Ribble Valley Borough Council
Housing & Development Control

Application no: **3/2021/0106**

Address: **35 College Close Longridge PR3 3AX**

Proposal: **Proposed conversion of garage to study and first floor extension**

BLOCK PLAN - SCALE 1:200

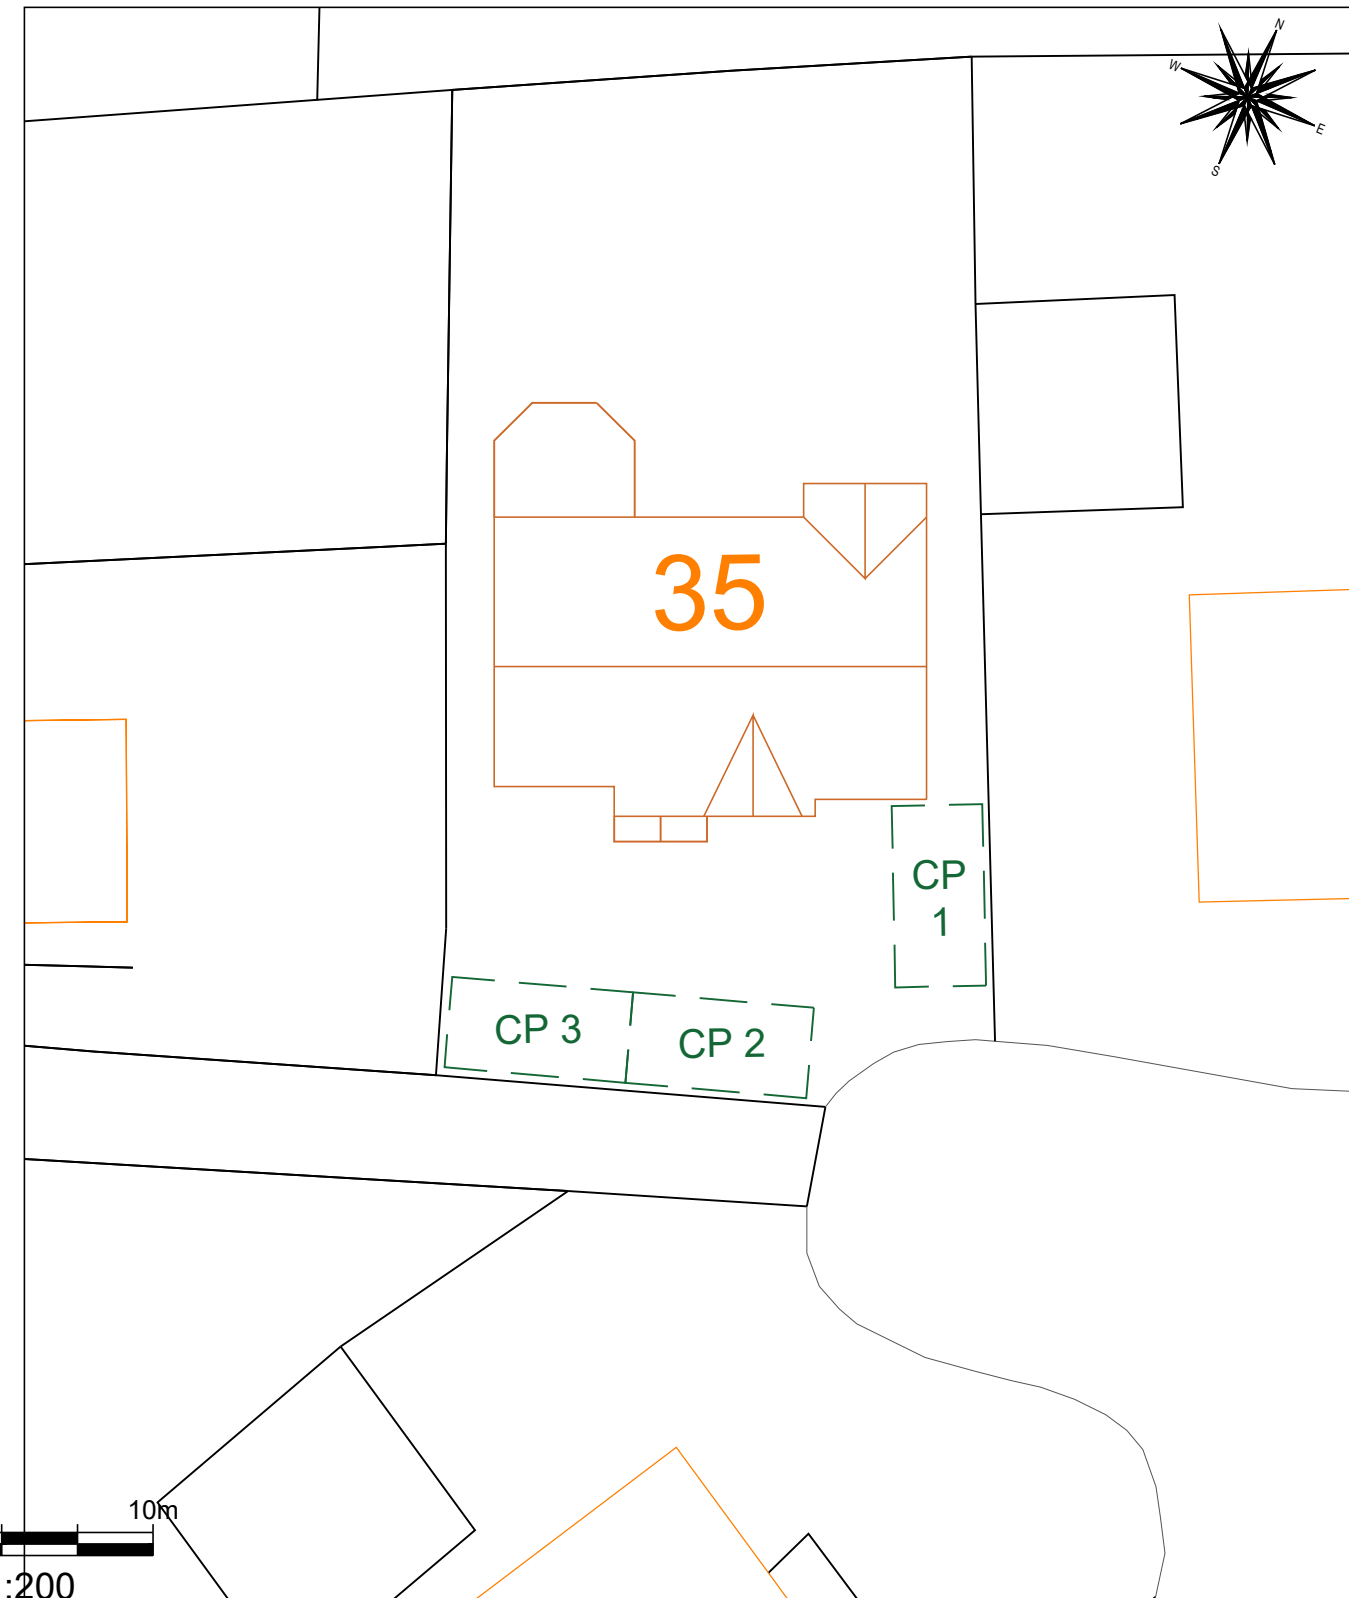
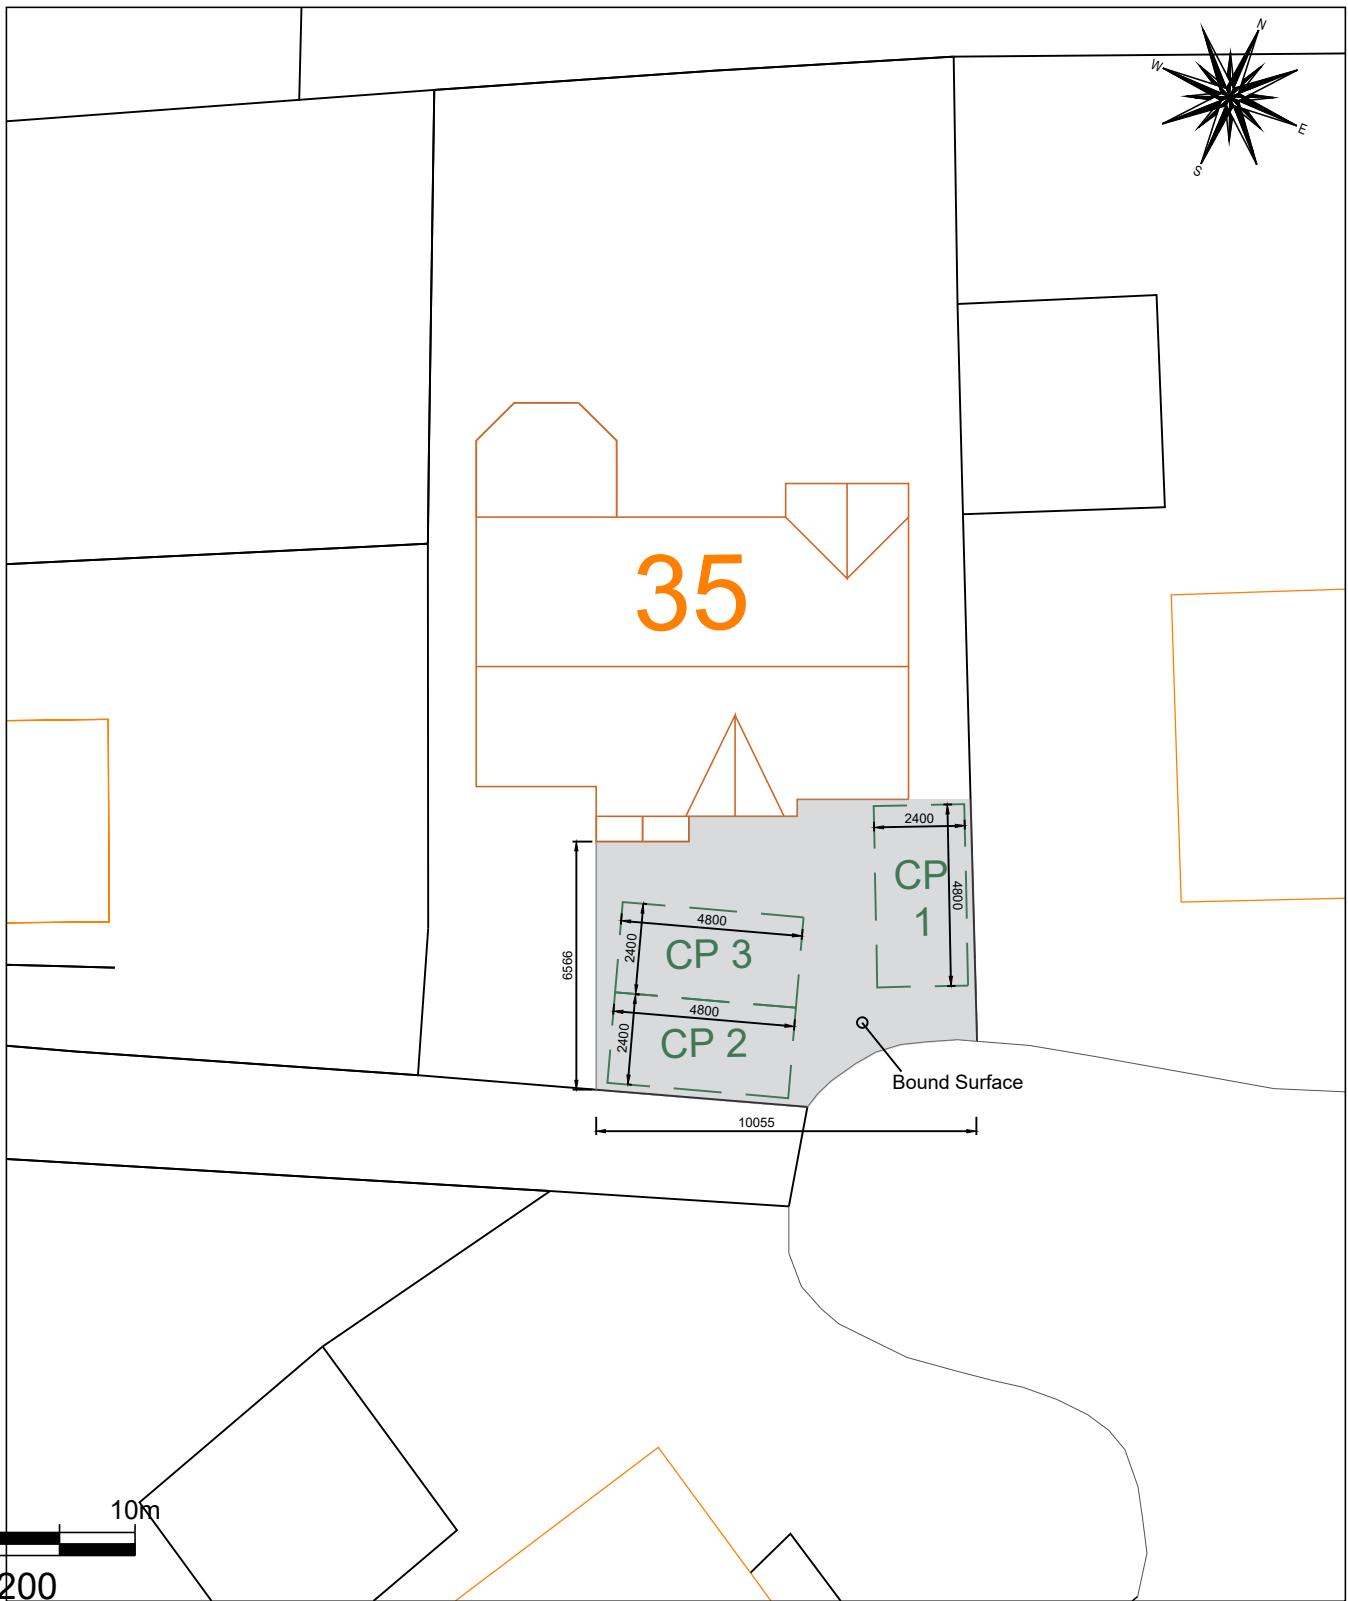
The proposed extension and conversion of a garage to a study will involve a reduction to the existing parking arrangements by the removal of the existing garage parking. However, the applicant proposes to accommodate the required parking provision within the curtilage of the property, and should the applicant provide a sufficient parking layout which illustrates the dimensions of the proposed parking area to be paved with a bound surfaced material then this would satisfy the associated highway concerns.

I ask that the plans are revised, demonstrating the above before I can make any further comments on the matter.
